CITY OF ALBUQUERQUE

PLANNING DEPARTMENT – Development Review Services

June 11, 2014

**RE: Replat of Tract 43-C, Unit 2, Atrisco Grant
Drainage Report and Conceptual Grading & Drainage Plan
Engineer's Stamp Date 5-16-2014 (File: L09D043)**

**ROUGH GRADING
PLAN**

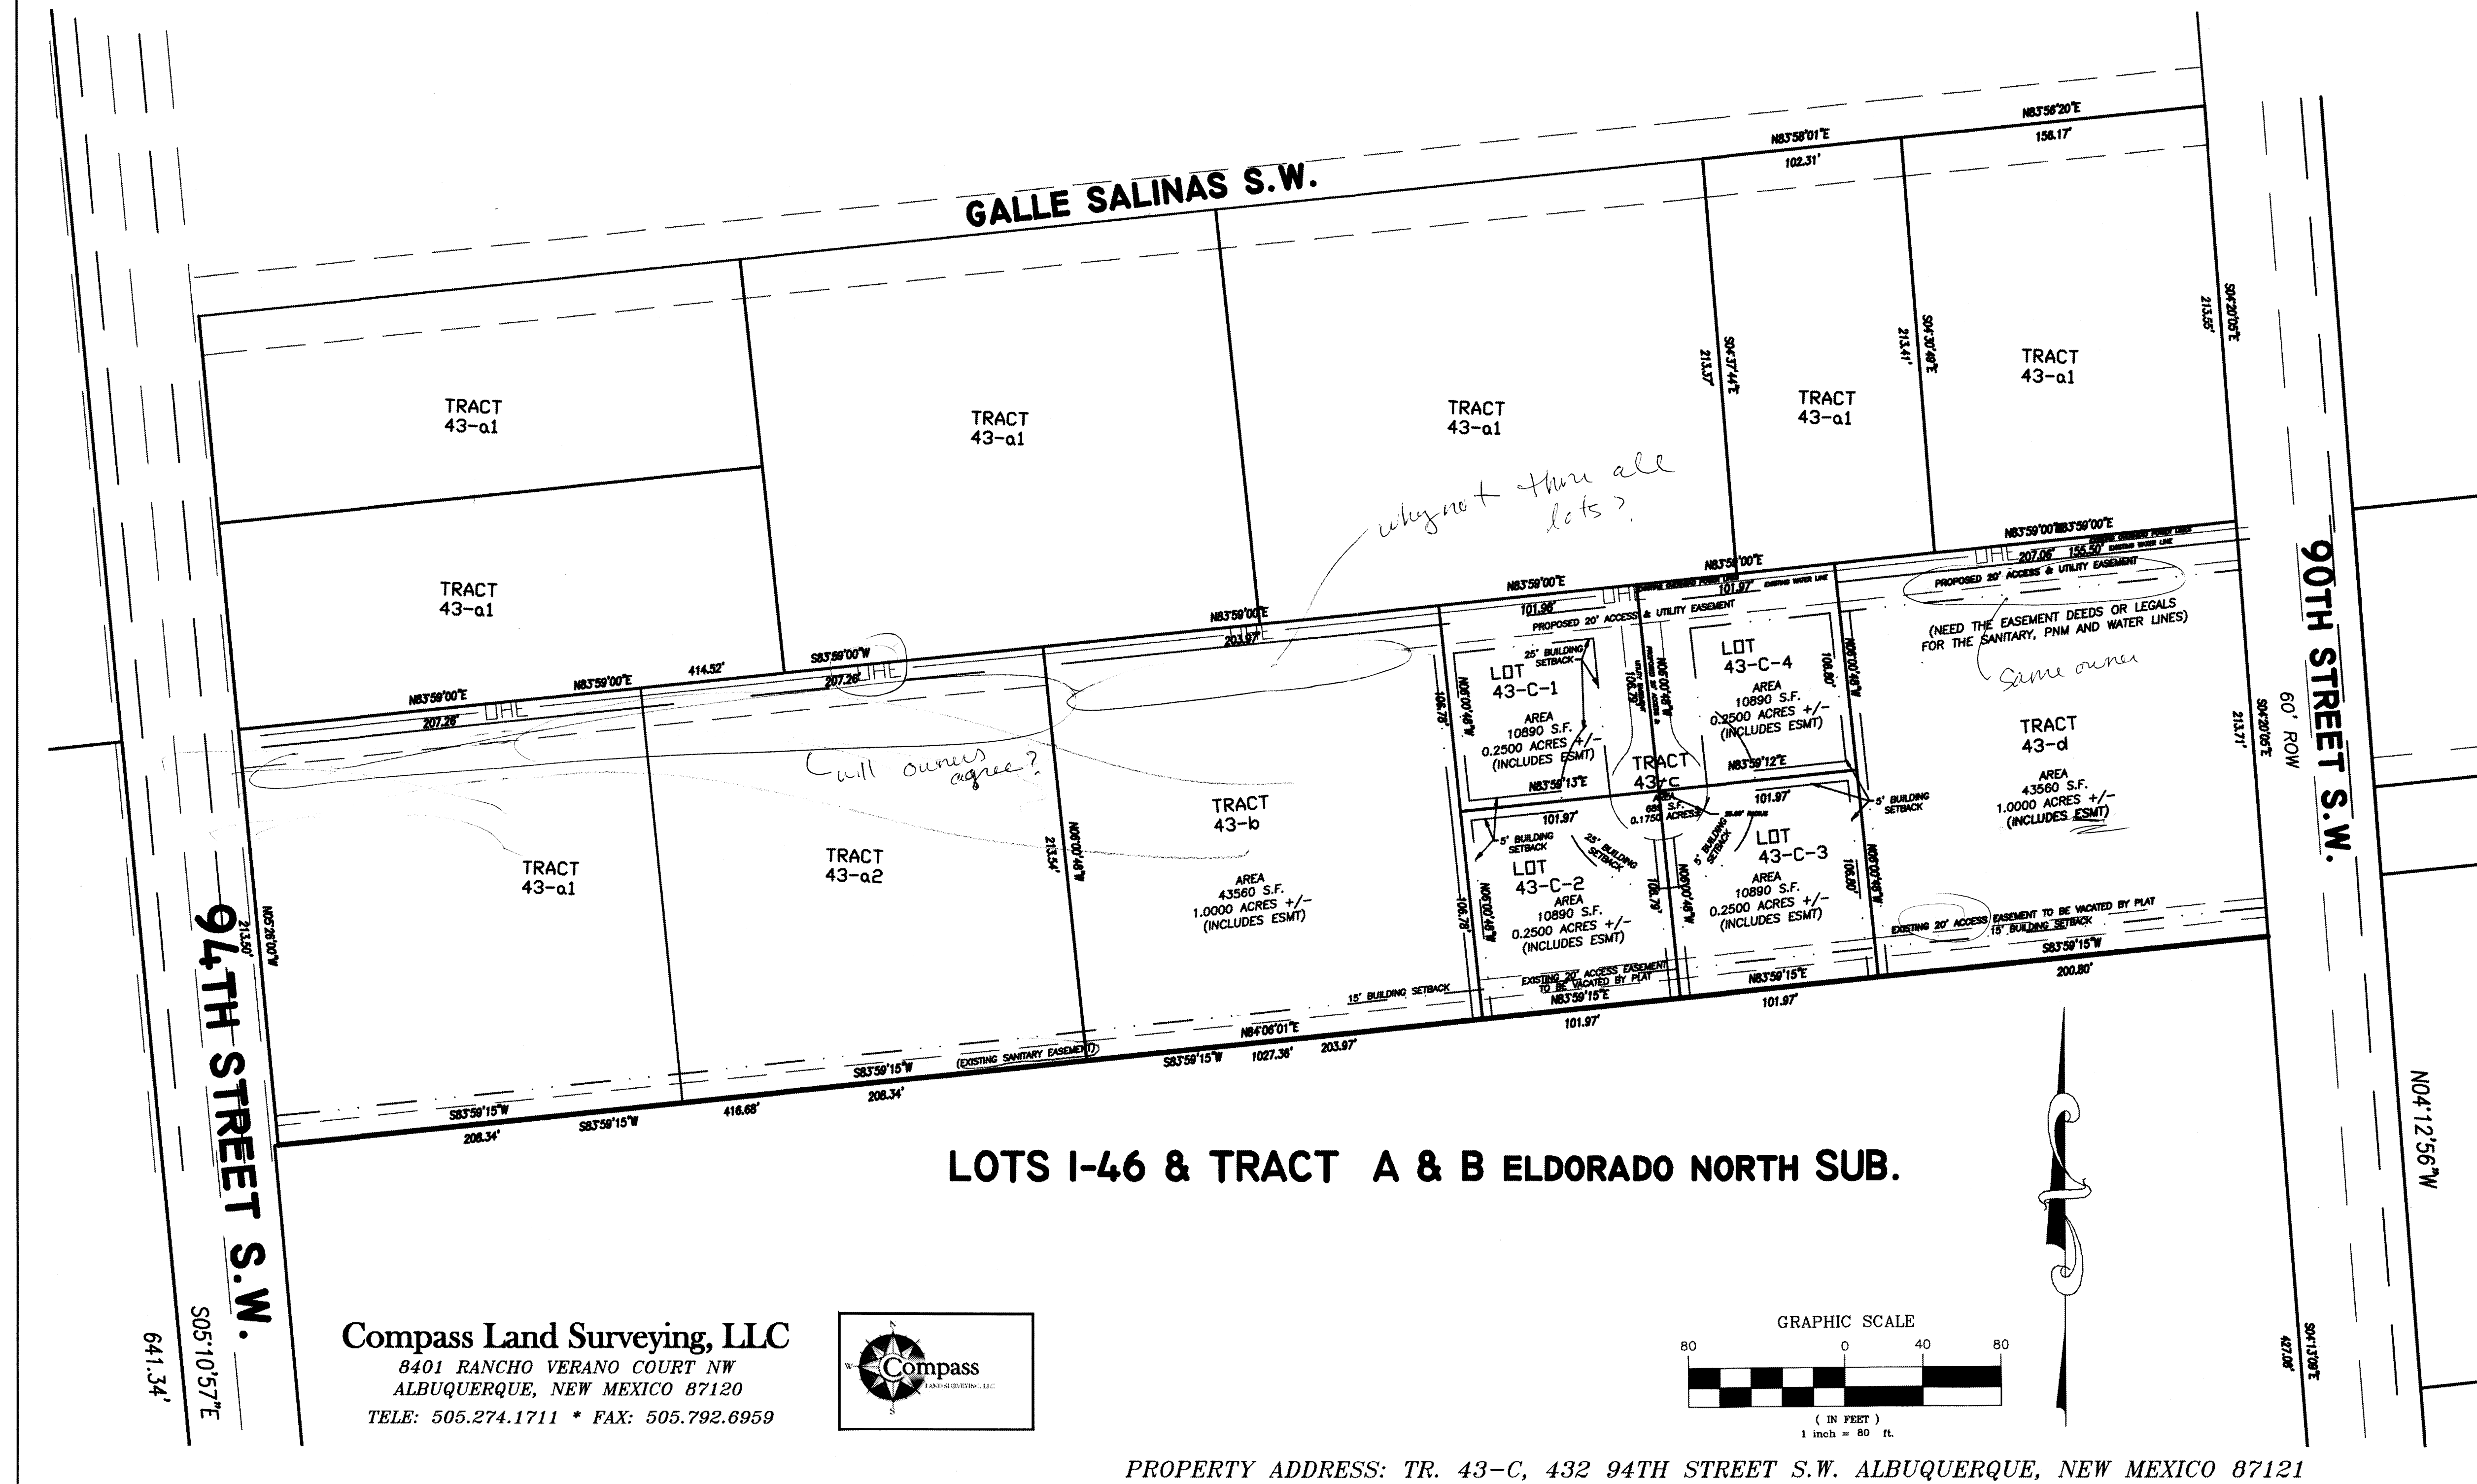
1. The Rough Grading Plan shows a wall along the east edge, but it does not match any of the hatch patterns shown on the legend. Is this a retaining wall? If so, please match hatch intended. The south wall shows an existing wall and also a short length of retaining wall at the east end. Why is there a double wall?

2. The walls shown on the Rough Grading Plan have Bottom of Wall elevations that do not match the grade, neither proposed nor existing. Top of Wall elevations need to be corrected as well.

3. How do offsite flows from the west cannot continue through, given that a wall cuts off that flow? It is unclear how offsite runoff flows through lots. Drainage easement goes only partially thru lots on west, and does not continue all the way through. Grades do not support flow from cul-de-sac to access road.

4. It is not clear where proposed grade lines tie into existing grade lines. Show spot elevations around proposed dwelling units.
5. Show contours beyond south property line.

6. On-site shallow ponding concept should be shown on rough grading plan.
7. Indicate the amount of discharge each lot is allowed and the amount to be ponded.
